CLAREMONT RANCH WEST - SKETCH PLAN

MINOR
AMENDMENT

SKP V_1 planning redlines only.pdf Markup Summary 2-16-2021

CLAREMONT RANCH WEST - SKETCH PLAN

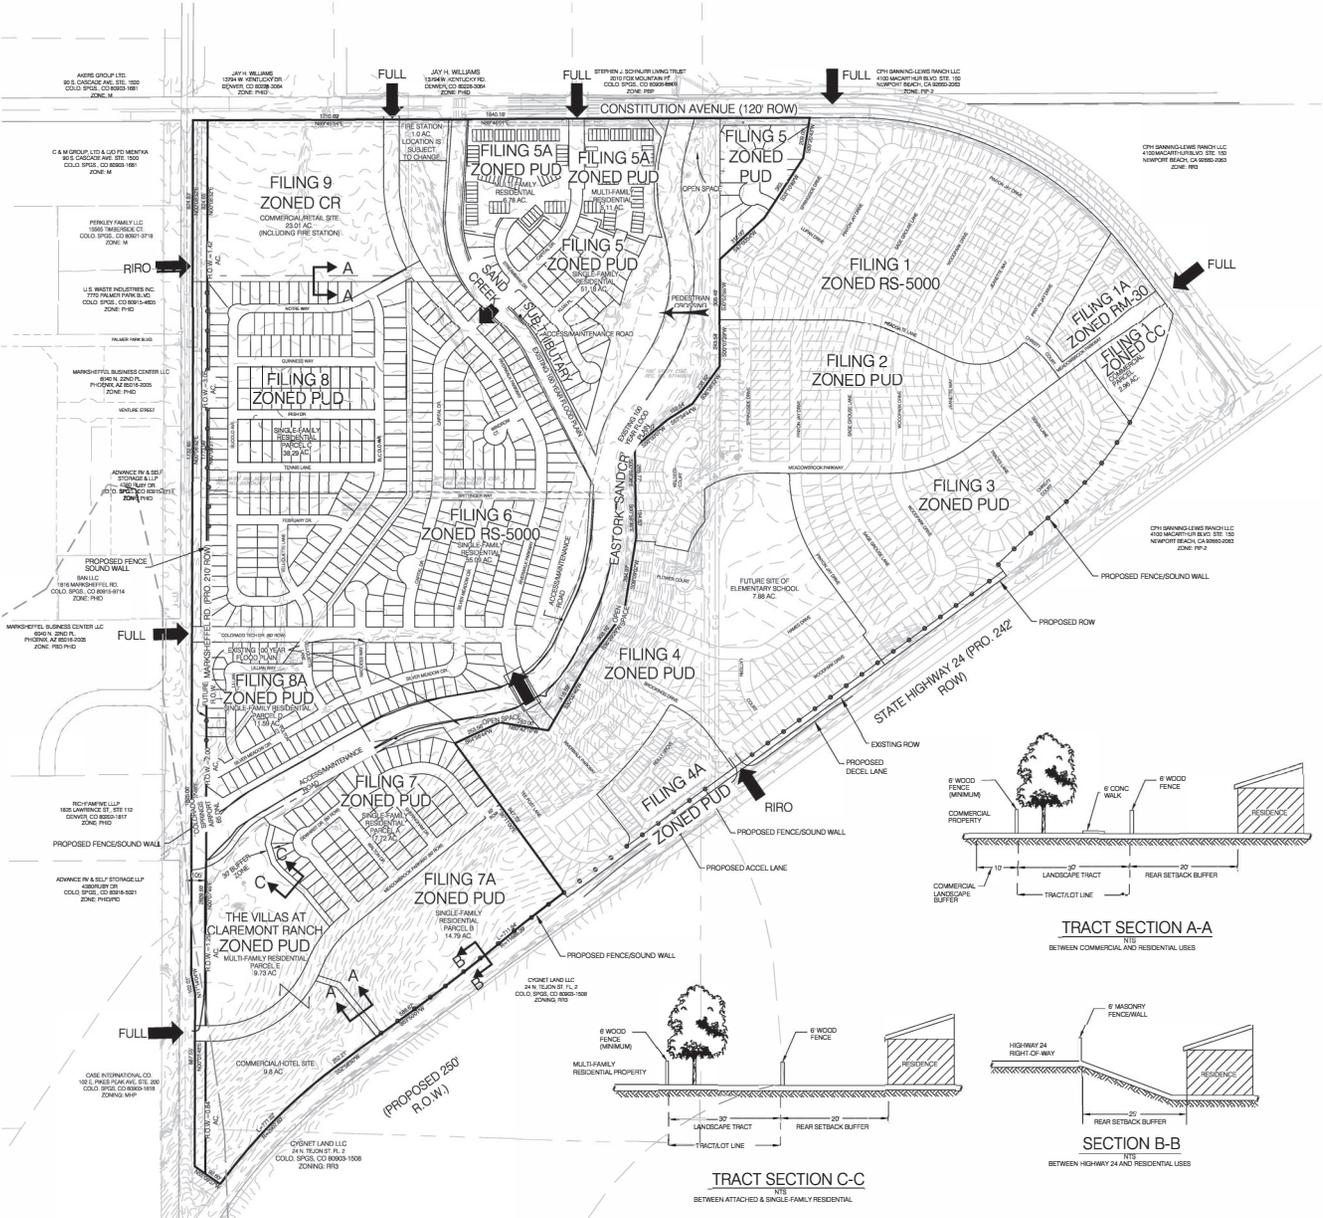
where is tract A that is now being included in this development?

Please cloud all the amended items on the SKP Map.

is this multi-family (or attached single family lots?)

Is this to be included in the amendment now or will commercial be developed here?

label all roadways, provide width, classification, public private

Staff recommends identifying the adj densities within the SKP for the developed areas to further the discussion on compatibility....somewhere in a table or on drawing...

identify the buffer/setback from the industrial properties please (the row counts towards that requirement)

provide detail or description

### COVER SHEET

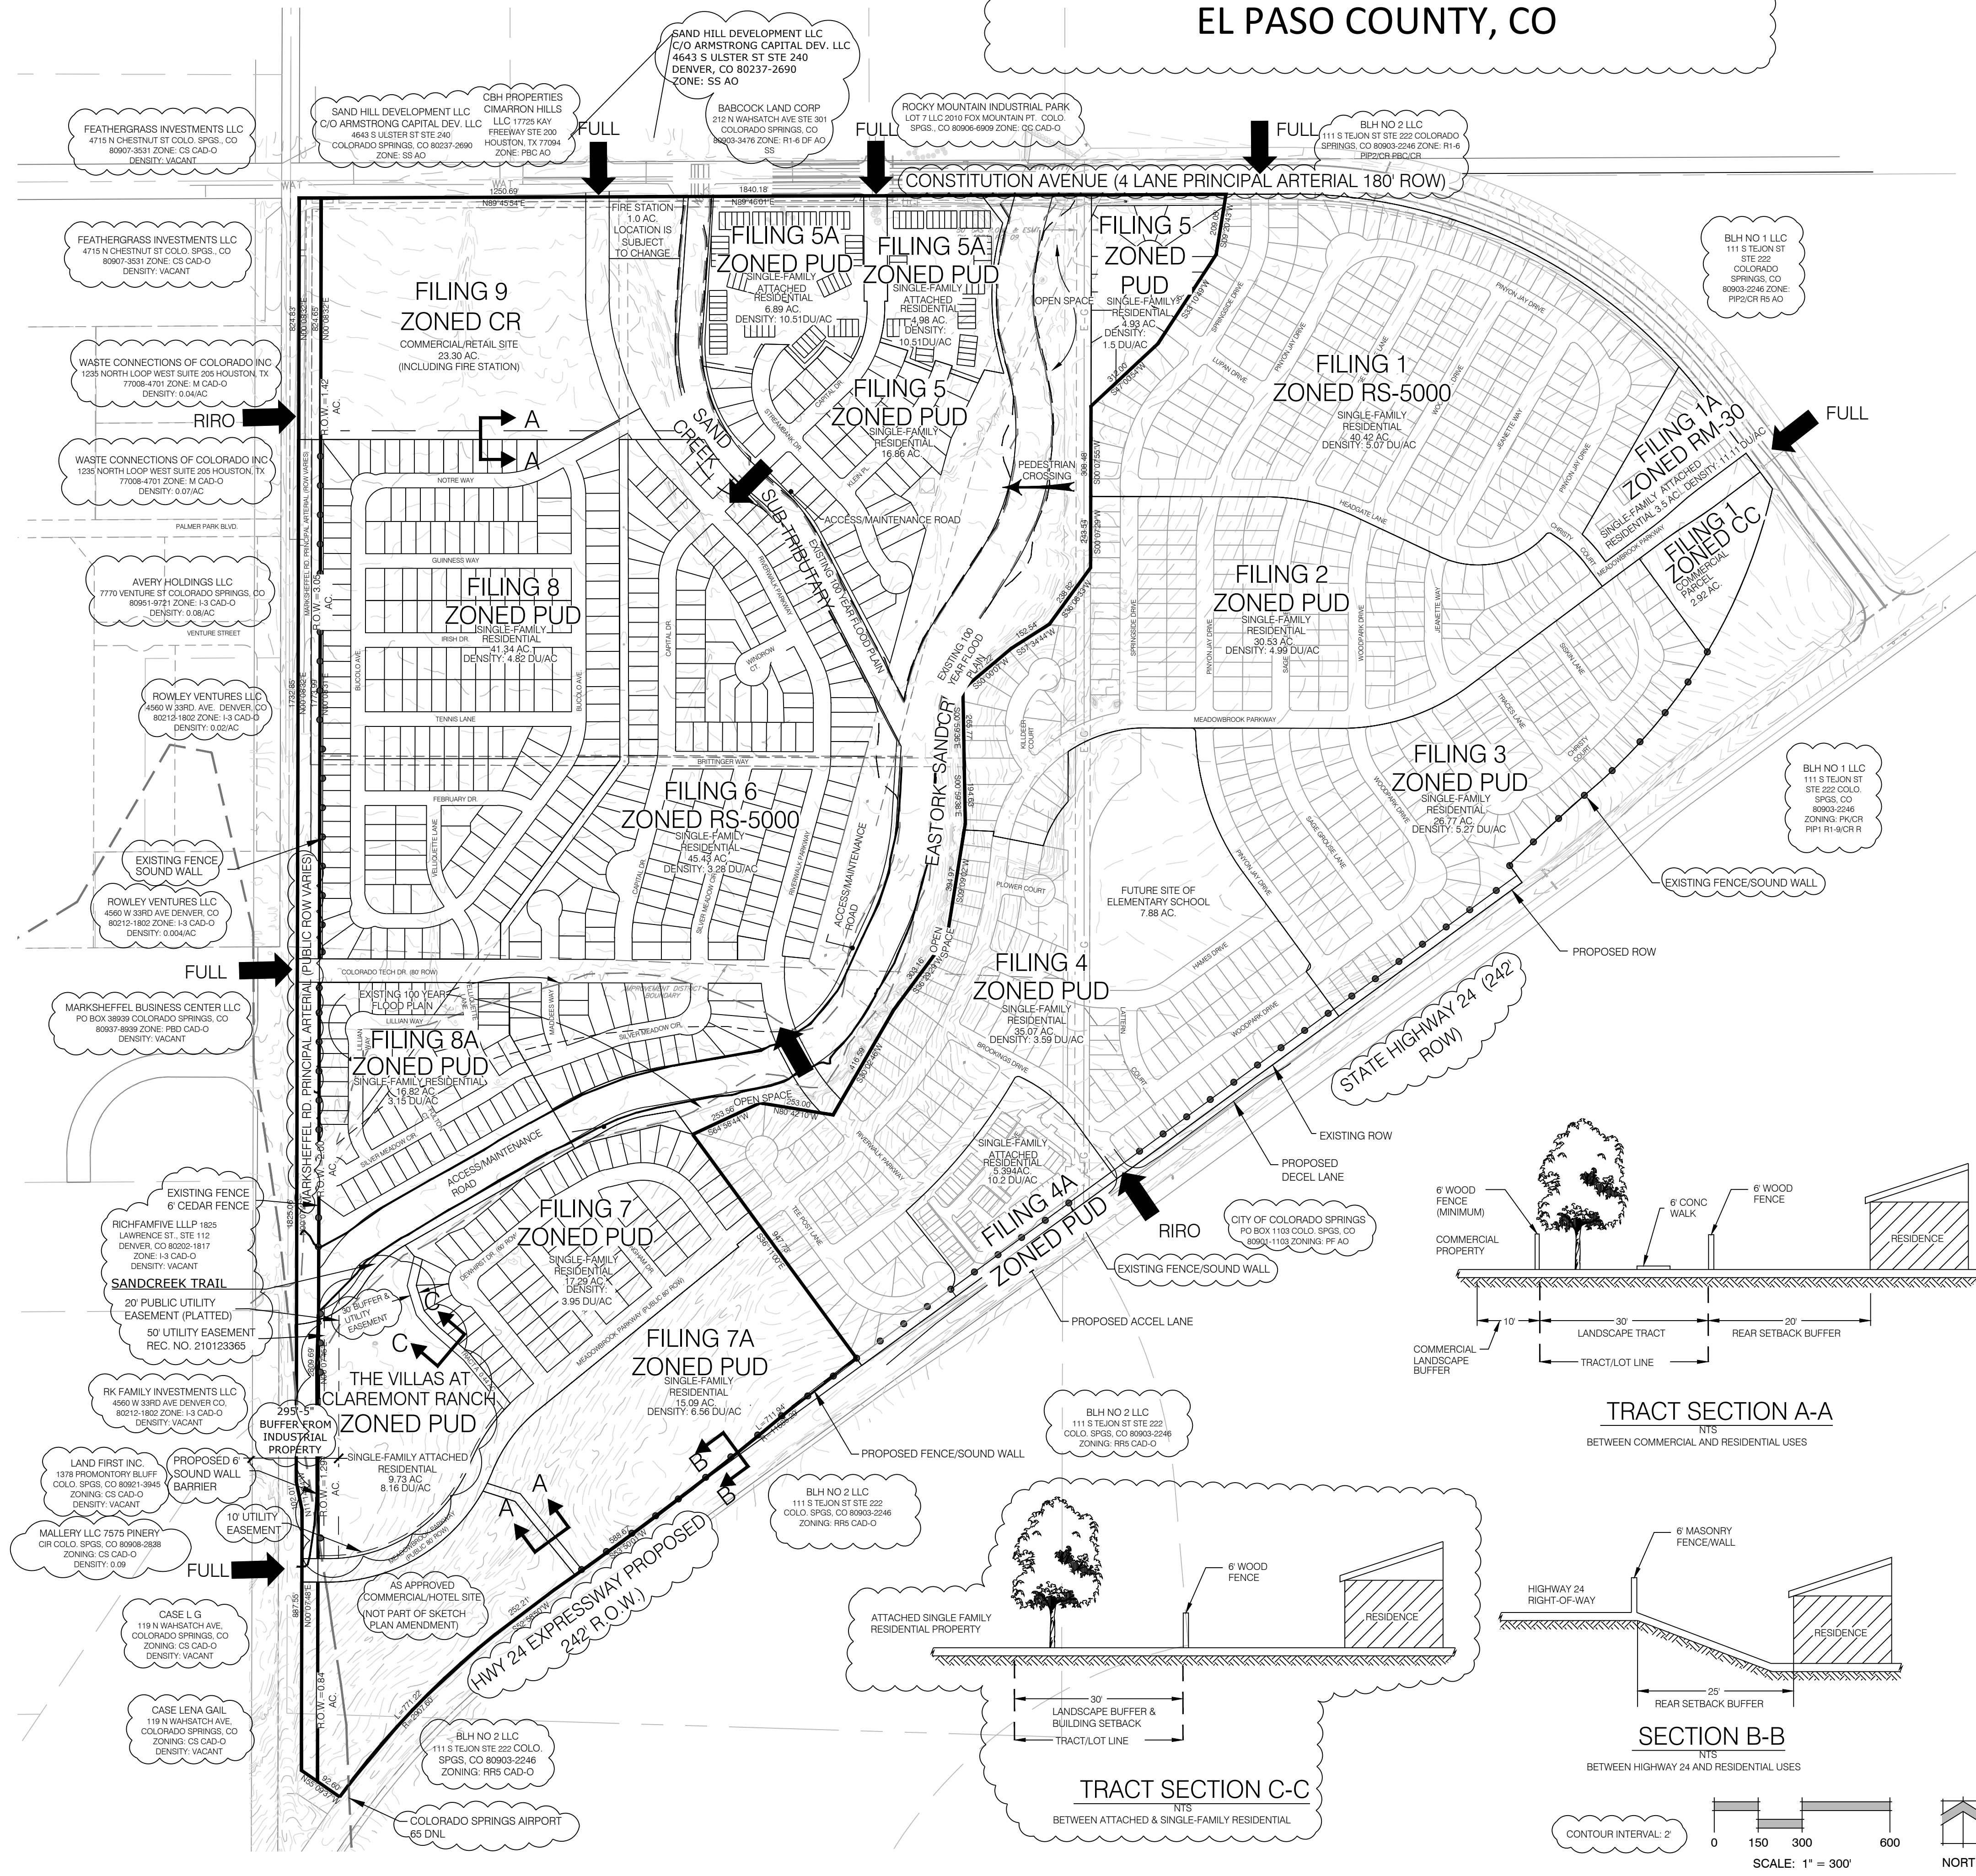
Title, Section,
Township, Range,
County, State to all
sheets please

please cloud which
phase is being
amended

year should change
for this phase and
any future phases- if
the phase is
completed state
completed

please cloud which
phase is being
amended

I have uploaded the
SKP checklist, please
ensure all information
is depicted on plan-
Thank you

please check numbers here w this amendment
commercial is going down SF up

what who will maintain this amended area?
